## WEST SUSSEX COUNTY COUNCIL CONSULTATION

<b>TO:</b>	Arun District Council FAO: Jessica Riches
<b>FROM:</b>	WSCC – Highway Authority
<b>DATE:</b>	31 October 2024
<b>LOCATION:</b>	Land North of Sefton Road and West of main access to new development Pagham
<b>SUBJECT:</b>	P/104/24/PL Erection of Ambulance Community Response Post (ACRP) and provision for parking of two emergency vehicles. This site falls within Strategic Site SD2, CIL Zone 1 (Zero Rated).
<b>DATE OF SITE VISIT:</b>	Desktop study undertaken (site visited at outline application stage)
<b>RECOMMENDATION:</b>	Advice/no objection

Drawing Title	SITE PLAN	Paper Size	A4
Date	July 2024	Drawing No.	5 2 4 / 0 2 2 / 9 8
			A

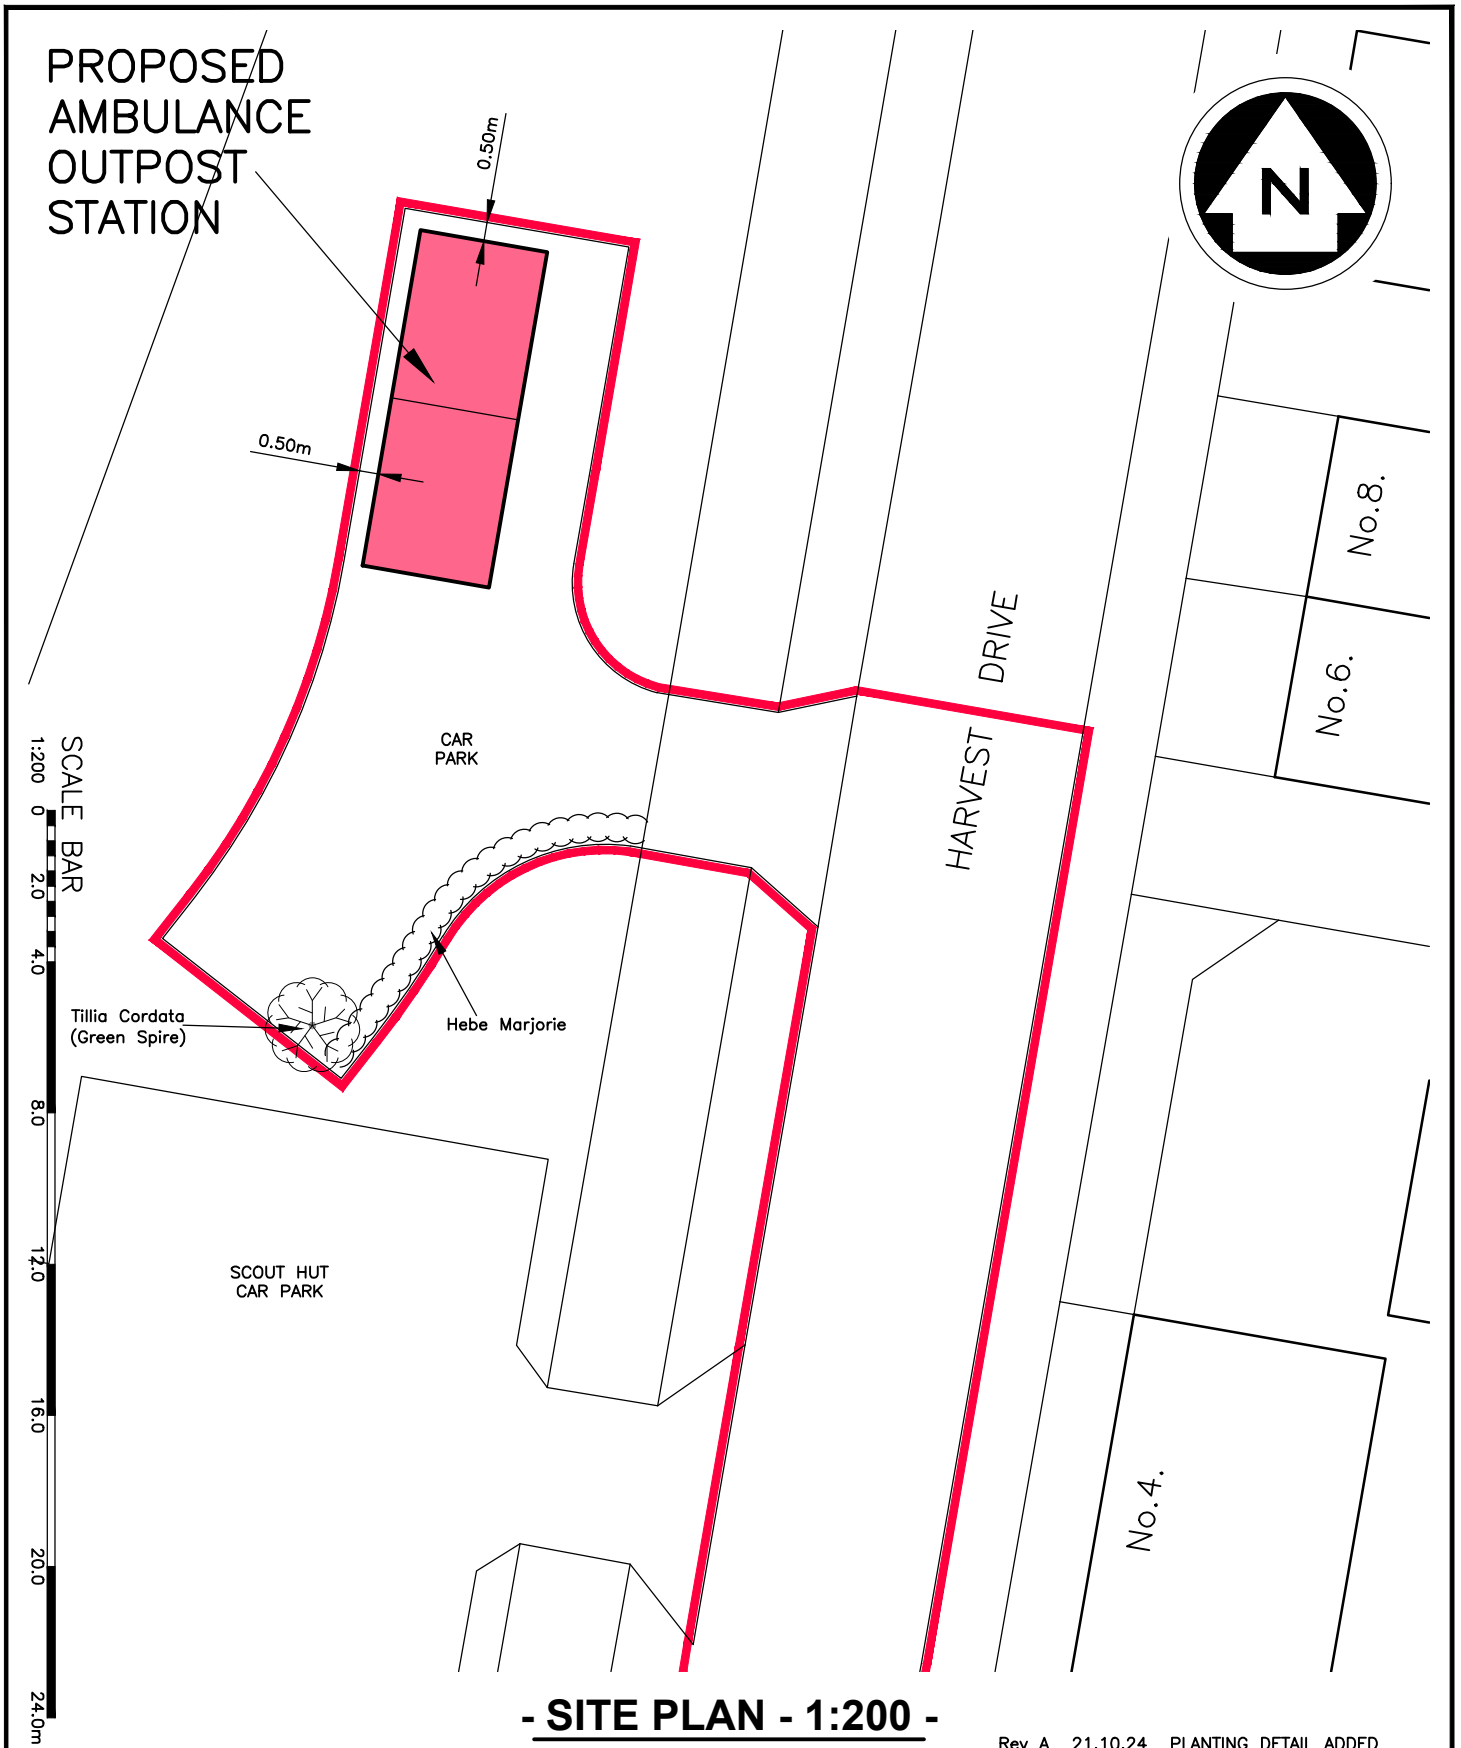
With regard to visibility from the access point, it is observed that a hedge is proposed along its southern edge and taken up to the highway boundary. The Highway Authority will require that this hedge, when mature and where it meets the highway, does not exceed 0.6m high in order to maintain visibility and intervisibility with other highway users, including pedestrians. A condition to secure this should be attached to any planning consent granted.

The proposal includes provision for the parking of two ambulances which, according to the Planning Statement submitted alongside the application, states that it is a unique use where the expected attendance would likely be by one ambulance crew but possibly two, from time-to-time. On that basis, space for two vehicles has been included within the driveway area shown on the submitted plan.

No part of the development shall be first occupied until pedestrian visibility splays of 2 metres by 2 metres have been provided either side of the proposed site vehicular

access onto Harvest Drive in accordance with plans and details to be submitted to and approved in writing by the Local Planning Authority. These visibility splays shall thereafter be kept free of all obstructions over a height of 0.6 metre above adjoining carriageway level or as otherwise agreed.

No part of the development shall be first occupied until the parking has been constructed in accordance with the approved site plan. These spaces shall thereafter be retained at all times for their designated purpose.
